Engineers Comments Regarding Surface Water Drainage

Application Reference:	P/43/25/PL	Reviewer Reference:	ADC/SB
Planning Officer:	Hannah Kersley	Date of Review:	28/10/2025
Site Name:	Land to the west of Inglenook Hotel 255 Pagham Road Nyetimber PO21 3QB		
Application Description:	Demolition of existing storage buildings and the erection of 6 No dwellings and associated works. This application affects the setting of listed buildings, is a Departure from the Development Plan and is in CIL Zone 5 and is CIL Liable as new dwellings.		
Assessment Number:	2 of 1

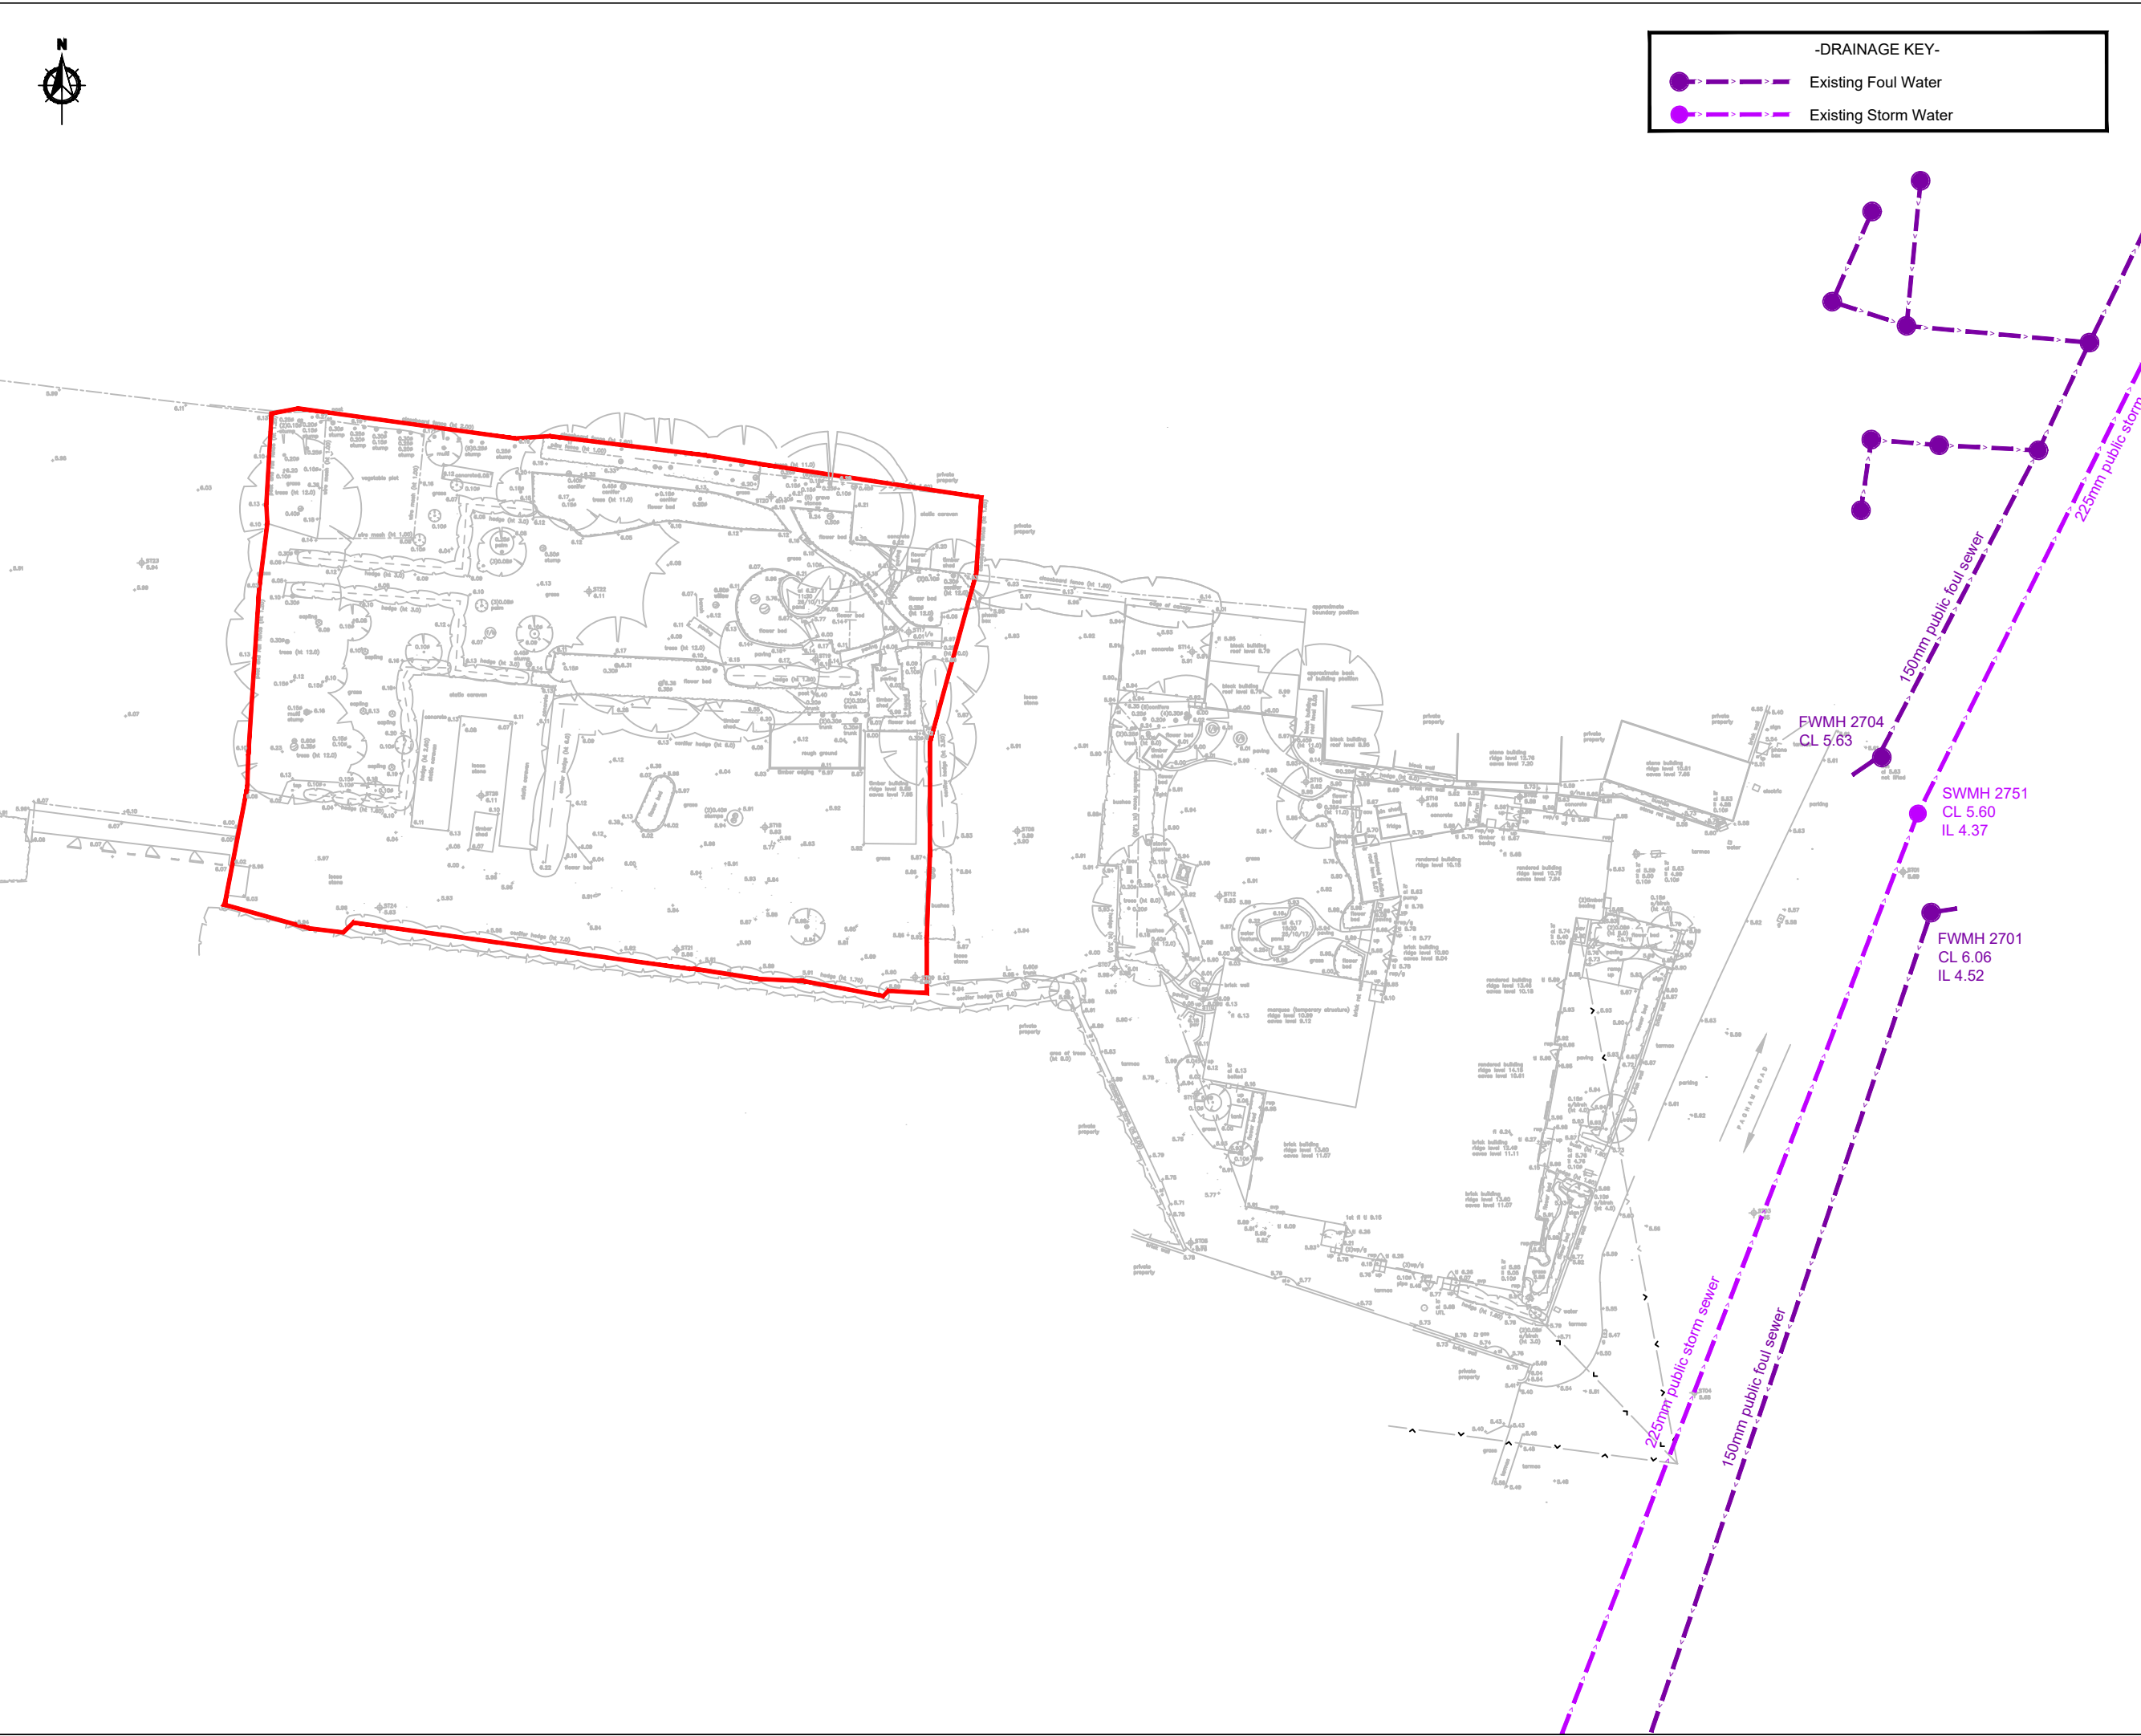
- 3.6. The access road drainage has not been adjusted following the previous objection, which still stands:
- 3.7. *The access road is claimed to be 'free draining', this is inappropriate. Groundwater levels are high enough that they may penetrate the subbase of the access road and insufficient depth of unsaturated ground is provided between the base of the road and the peak groundwater level. This means that surface water will not be adequately treated. Furthermore, the infiltration potential of the site has not been demonstrated (due to high groundwater), therefore there is a risk that the access road will flood.*

- 3.8. The designer states that the construction methods are dictated by the constraints of the site with regards to the existing trees. However, these constraints are a product of the access road location within the tree root protection zone of an offsite poplar which is the subject of a tree preservation order (TPO). The layout of the development has not been approved, and this conflict should be satisfactorily addressed so that the road is drained in a manner that does not increase flood risk, ideally to the satisfaction of the tree officer. The constraints of the site and this potential conflict should have been considered early in the design process, rather than sustainable drainage requirements being compromised.
